OUT17/26809

**Rocky Hill Coal Project (SSD 5156)**  
**Comment on the Response to Submissions RTS**

Mitchell Isaacs  
**Director, Planning Policy & Assessment Advice**  
 30 July 2017

Figure 2.29.14
Year 15

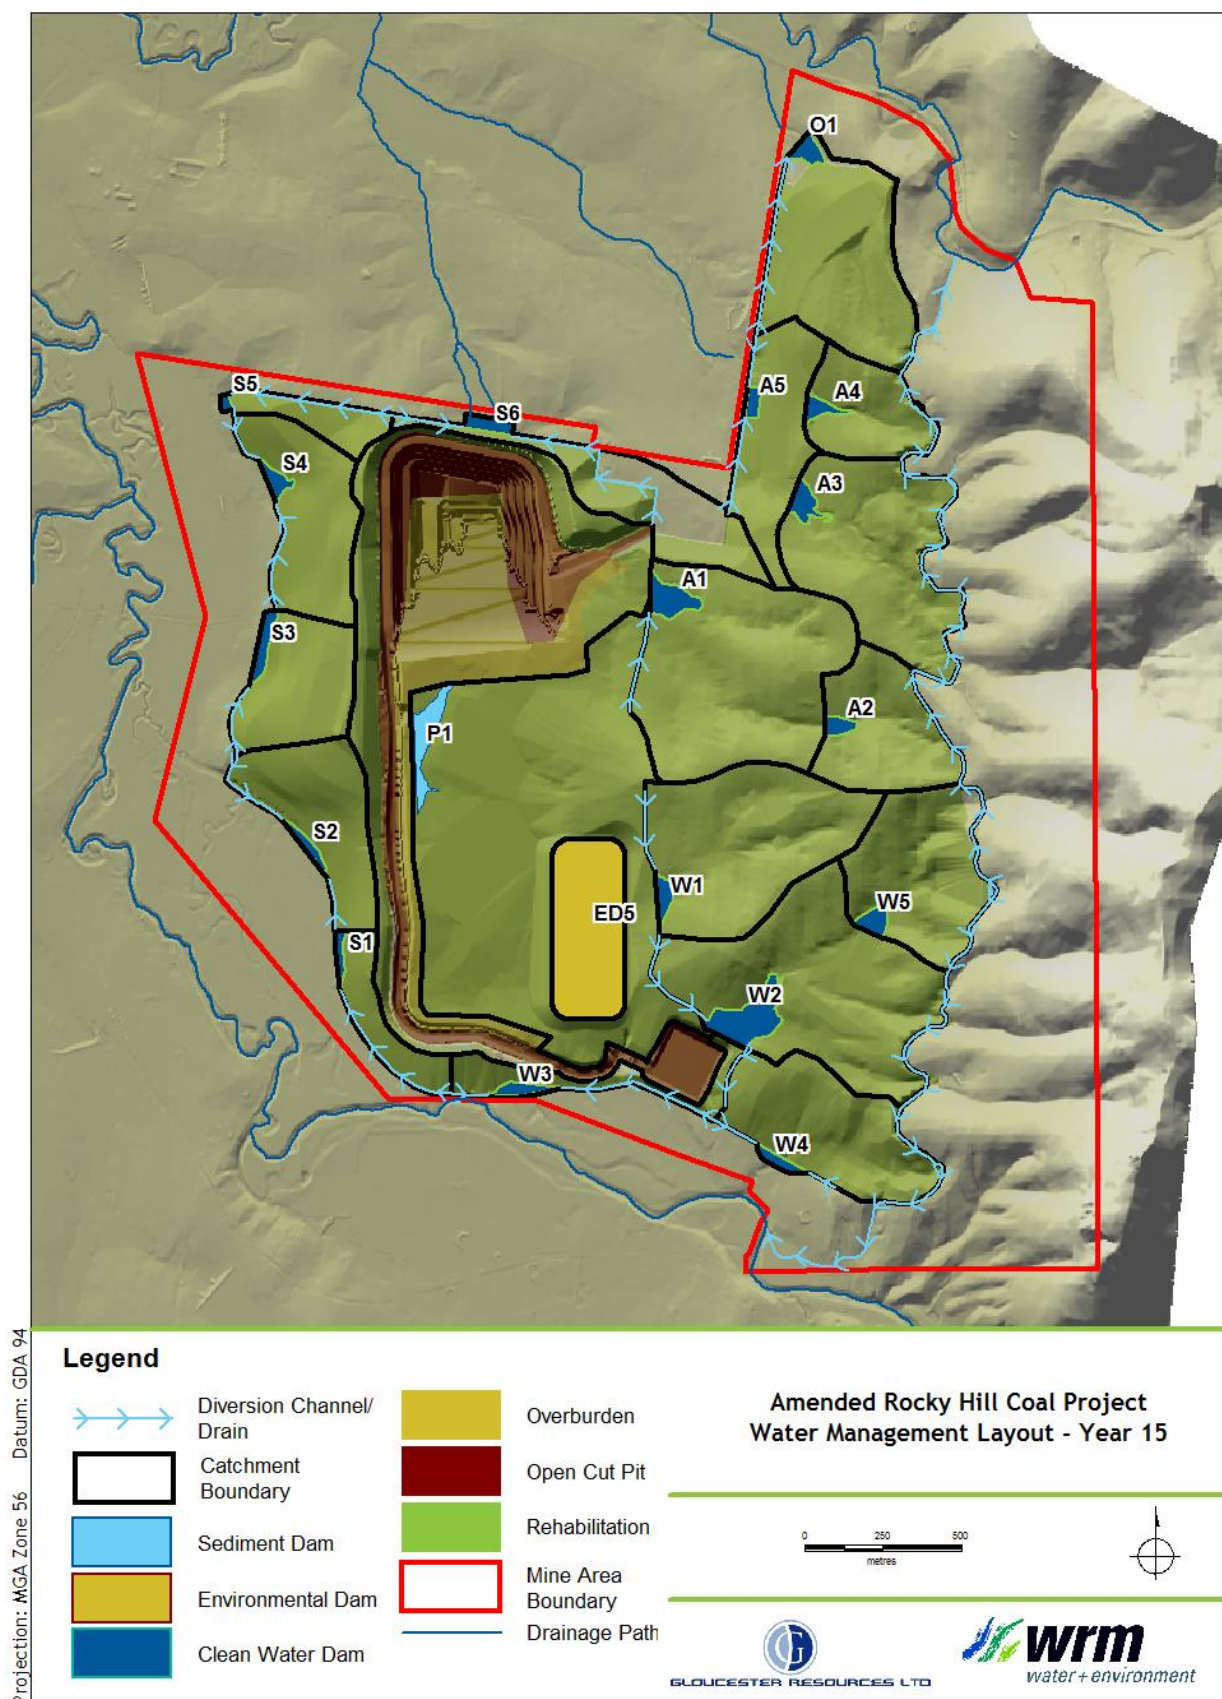
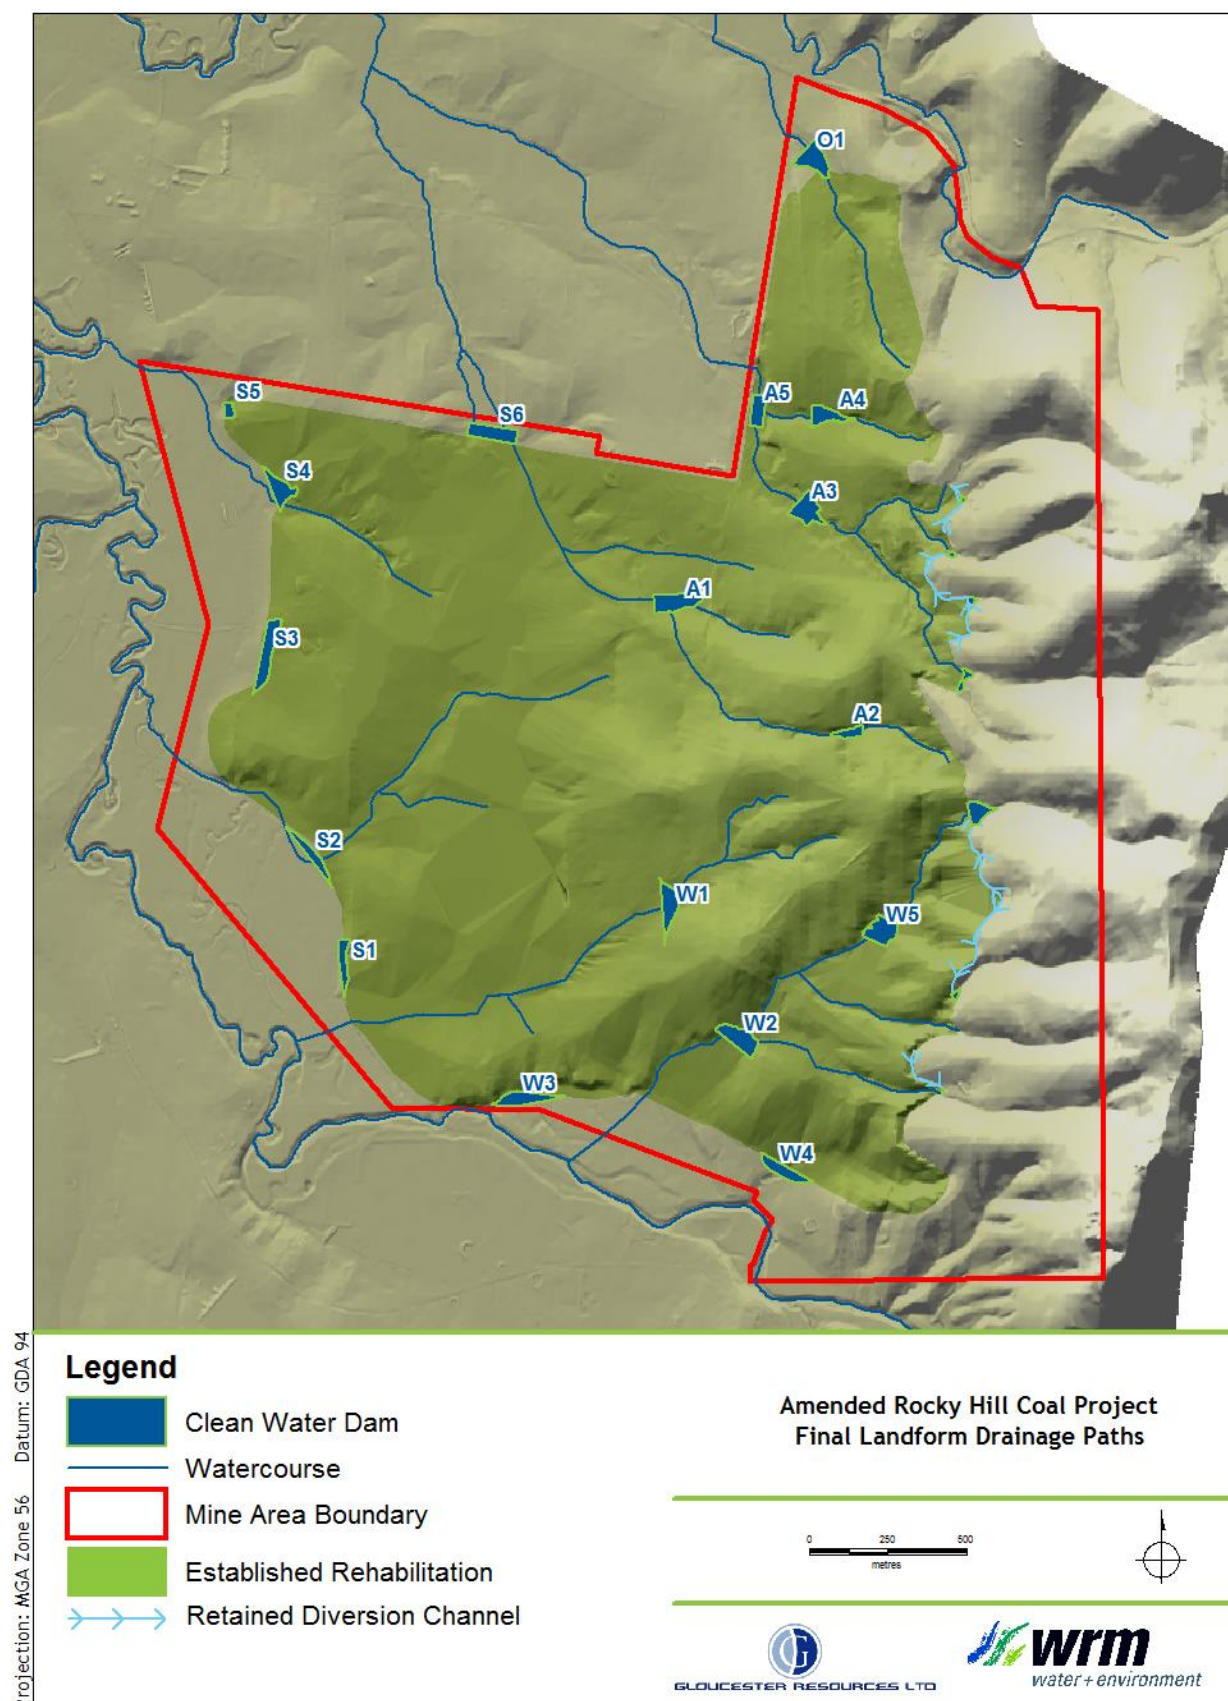
- The proponent should provide detailed information regarding the proposed catchment changes and shares required for dams S2, W2 and W3. It is noted that these dams are to be constructed on 3<sup>rd</sup> order streams however due to diversions will be 'effectively turkey's nest dams'.
